**Re: CHUZE Albuquerque
6600 Central Ave, SW
Albuquerque, NM 87121**

**Project Number: 21-6039-01
Permit Number: 2022-01930**

Subject: Planning Comments List

ITEMS FROM CORRECTION LIST DATED 06/10/22:

**A001**

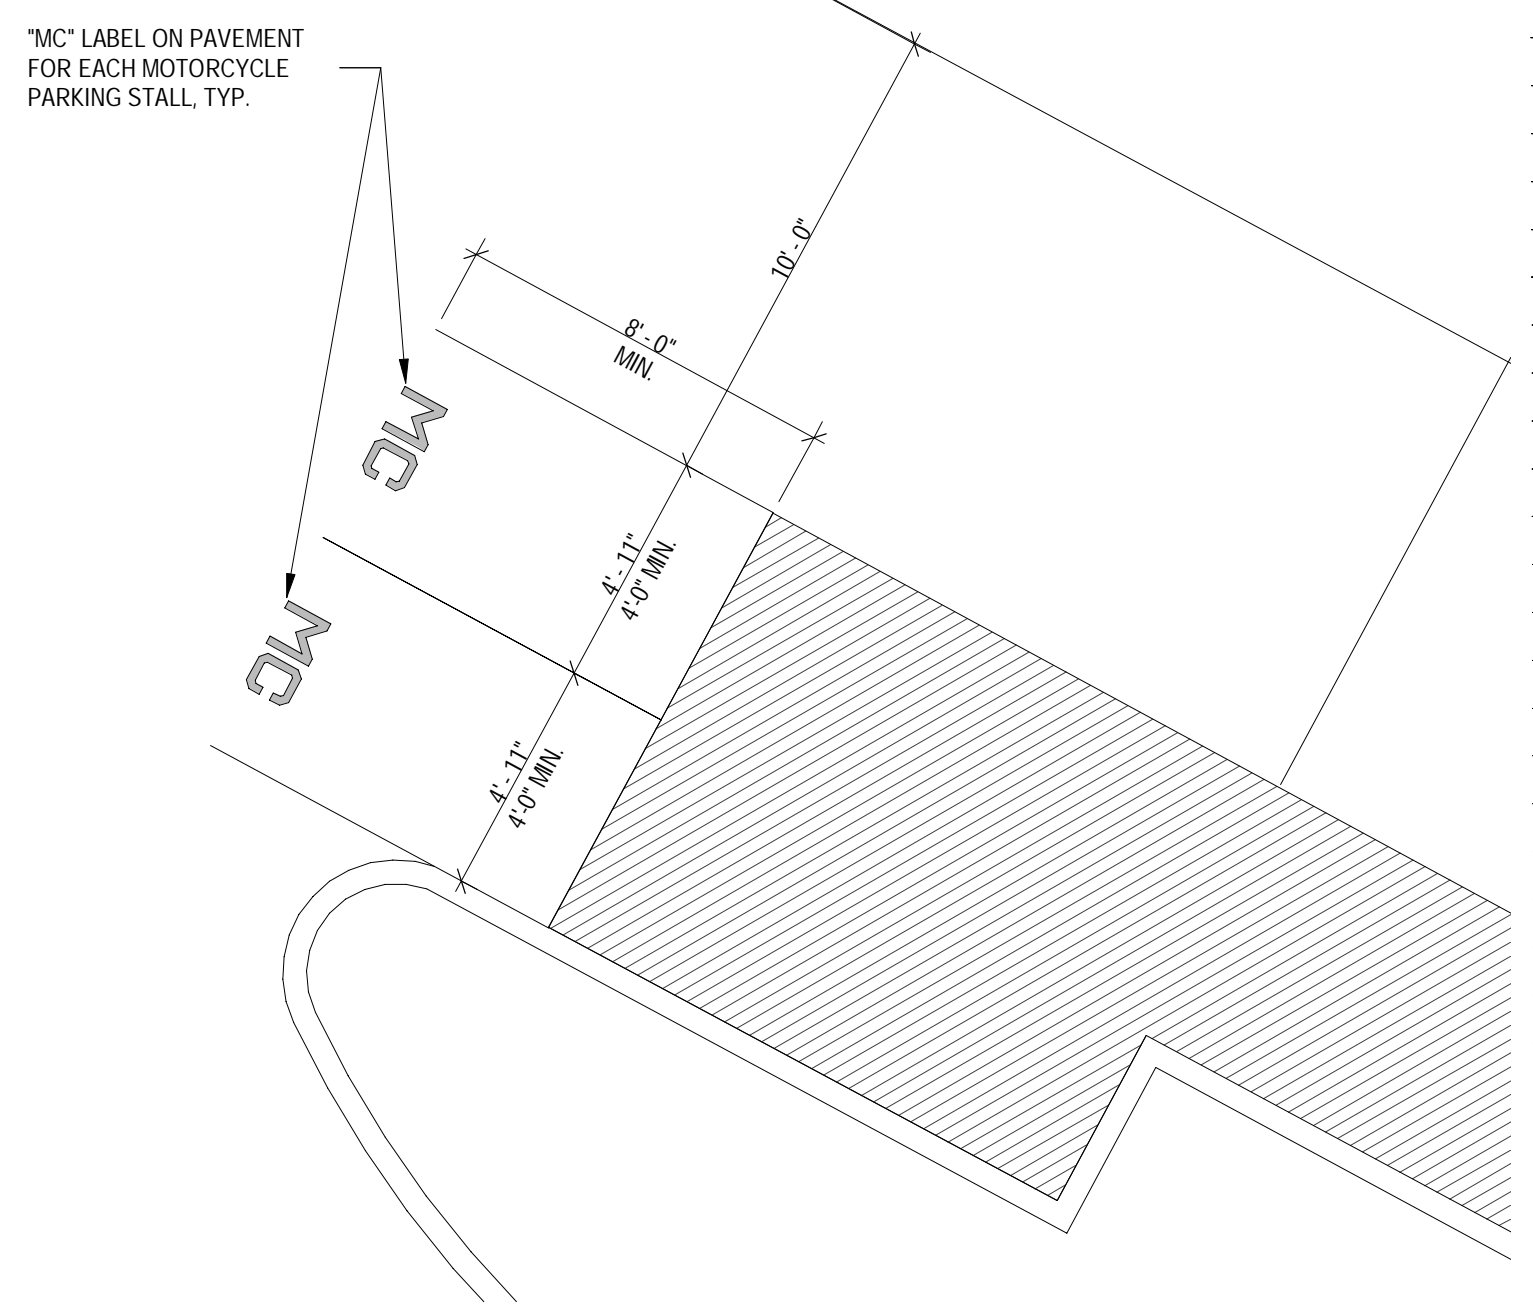
-
3. Provide a breakdown in change in parking as a percentage. Show approved parking total as compared to proposed parking total and the percent change.

Response: Percentage in parking change has been added. Please see sheet A001/ Parking Spaces Calculation – clouded Delta 8

**5 PROPOSED SIGNAGE CALCULATIONS**

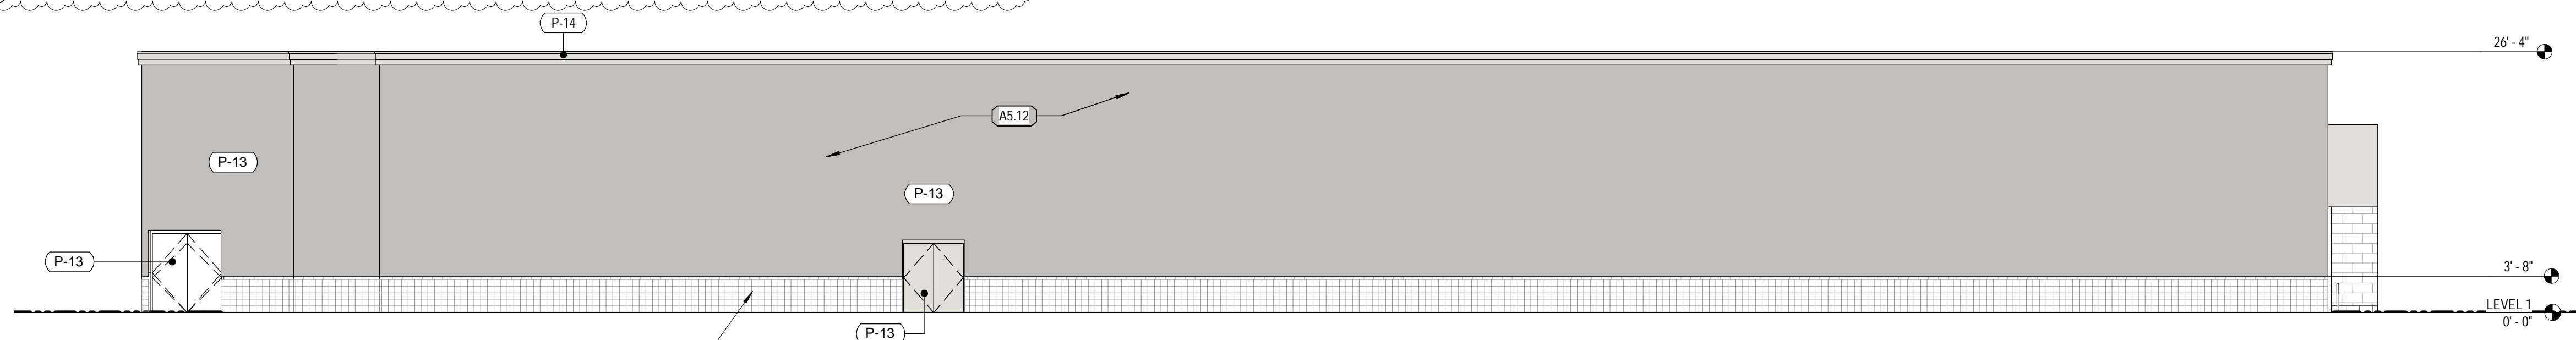
1. Please provide a breakdown of prior approved signage total square footage and location as compared to proposed signage location and square footage. Though this will be processed as a separate sign permit, approval for the signage as an AA is still required.

2. As per table 6-4-4, if the proposed signage is greater in area than the approved signage, the application will be processed as a major amendment.

Response: Proposed signage calculations have been added. Please see sheet A201/ Detail #5 – clouded detail 8 and attached document.

Response: Acknowledged. Total proposed signage area (177.80 SF) is less than the approved signage area (186 SF). Please see sheet A201/ Detail #5 – clouded detail 8 and attached document.
